**KIRKLEES METROPOLITAN COUNCIL
INVESTMENT & REGENERATION SERVICE**

**DELEGATED DECISION TO DETERMINE PLANNING APPLICATIONS TO
CARRY OUT DEVELOPMENT WITHOUT COMPLIANCE WITH PLANNING
CONDITIONS PREVIOUSLY ATTACHED**

Reference No:	2024/70/90404/W
Site Address:	12 Clough Head Farm, Clough Head, Slaithwaite Gate, Bolster Moor, Huddersfield, HD7 4NW
Description:	Variation of condition 2 (plans) on previous permission 2020/92391 for alterations to convert agricultural building to one dwelling
Recommending Officer:	Tom Hunt

Variation of condition 2 (plans) on previous permission 2020/92391 for alterations to convert agricultural building to one dwelling

SOUTH EAST ELEVATION SCALE 1:100
 AS PROPOSED

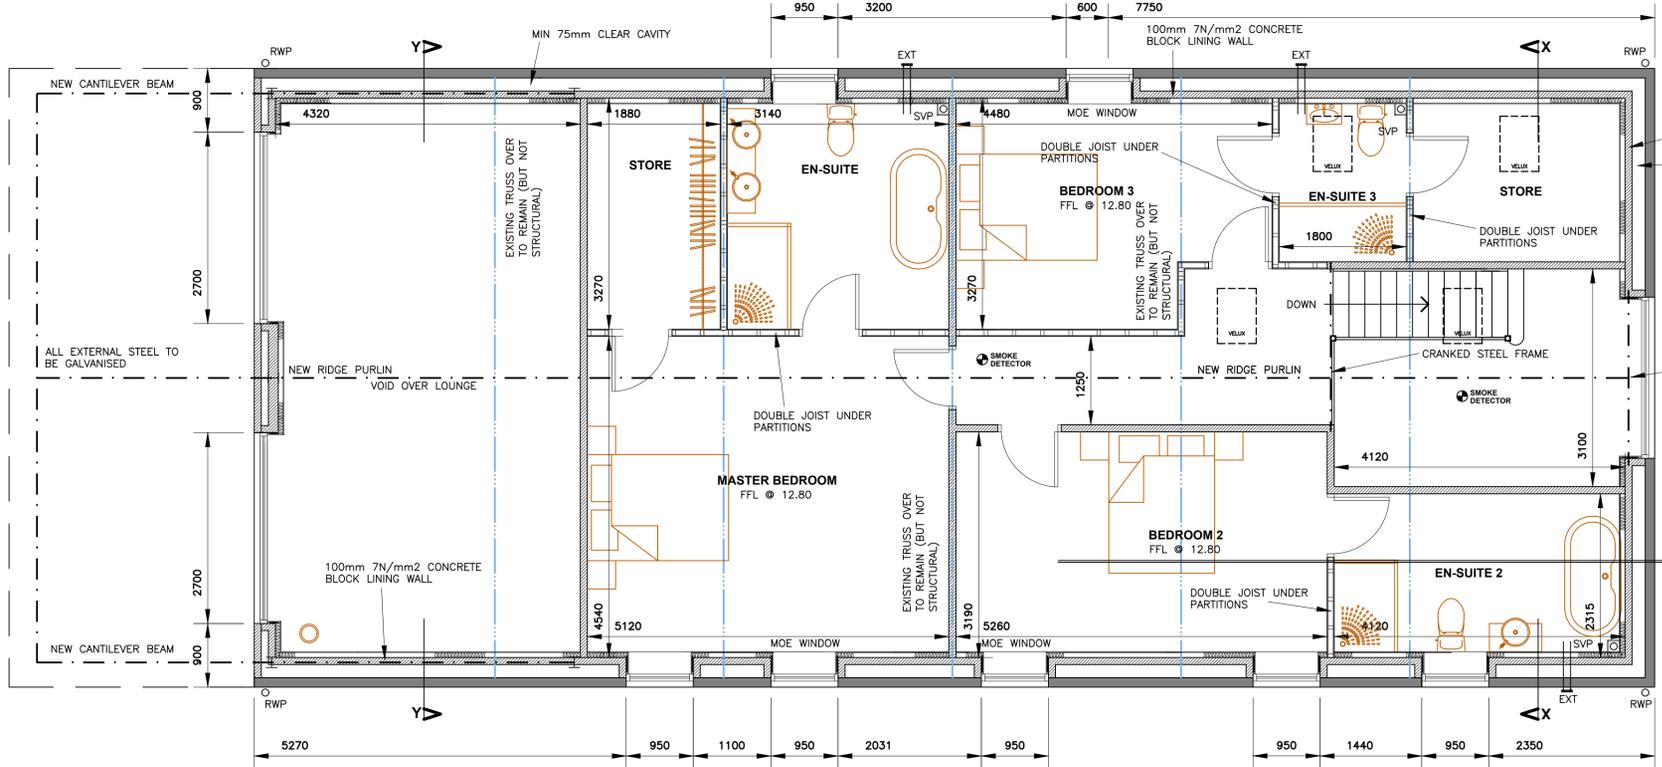
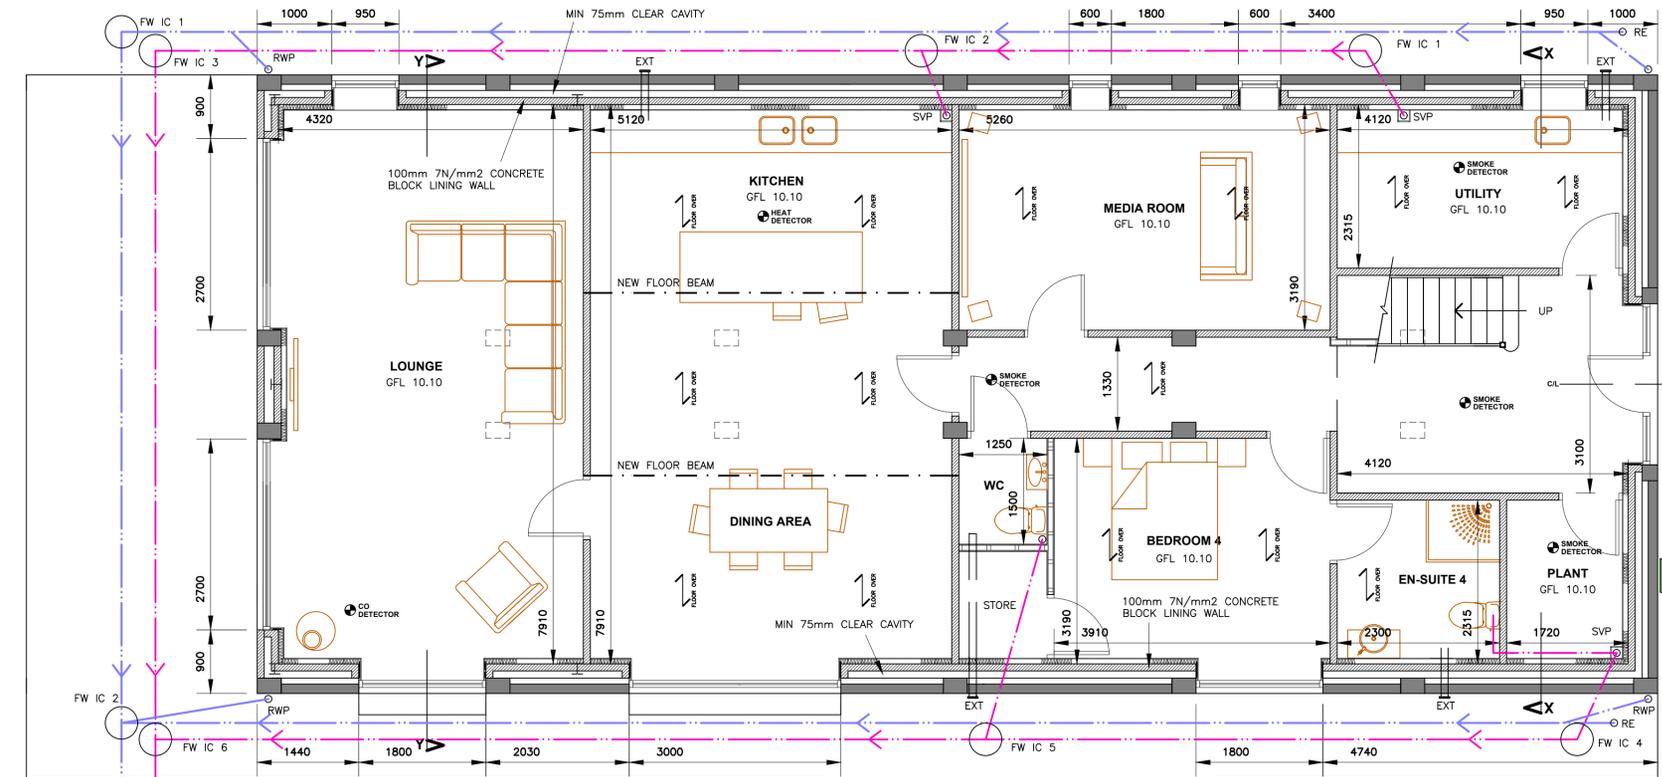
The amendments now proposed involve external changes to the fenestration/doorway openings, a greater overhang to its roof over the rear elevation, removal of solar panels and removal of a canopy to its side.

The proposal seeks to vary window and door openings to still have an arrangement to the side elevations suggesting a rural barn vernacular with windows of varying proportions, haphazardly placed. Visually the front and rear would appear to erode the original character and design of the ‘barn’ with glazed doorways and sections above however this would appear to resemble a more modern barn and as such acceptable.

The increase in the roof overhang at the rear elevation would be a minor visual variation to the original design with restricted views of this from most vantage points and thus would appear unremarkable.

The design would otherwise appear of simpler form than the previous permission with the removal of solar panels and canopy, and would retain, in essence, a barn like appearance in keeping with its pleasant setting.

GROUND FLOOR PLAN SCALE 1:50
 AS PROPOSED

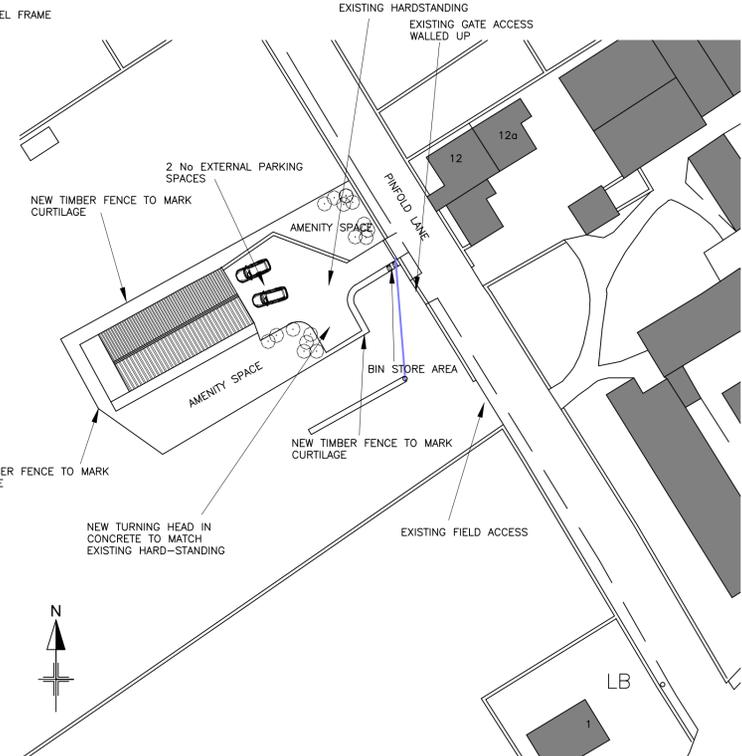
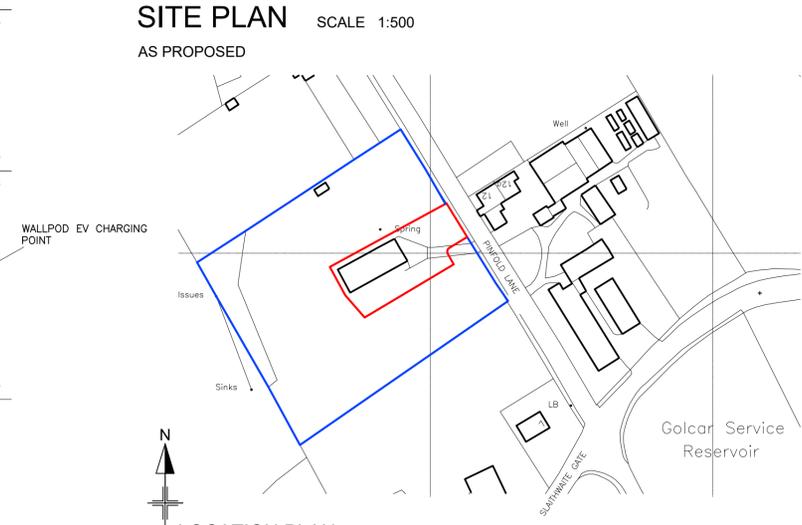
Internally, alterations to the floor layout include removal of integral parking to be given over to a double height lounge, removing a bedroom (the property is now proposed to be a four bedroom dwellinghouse) and other room reconfigurations.
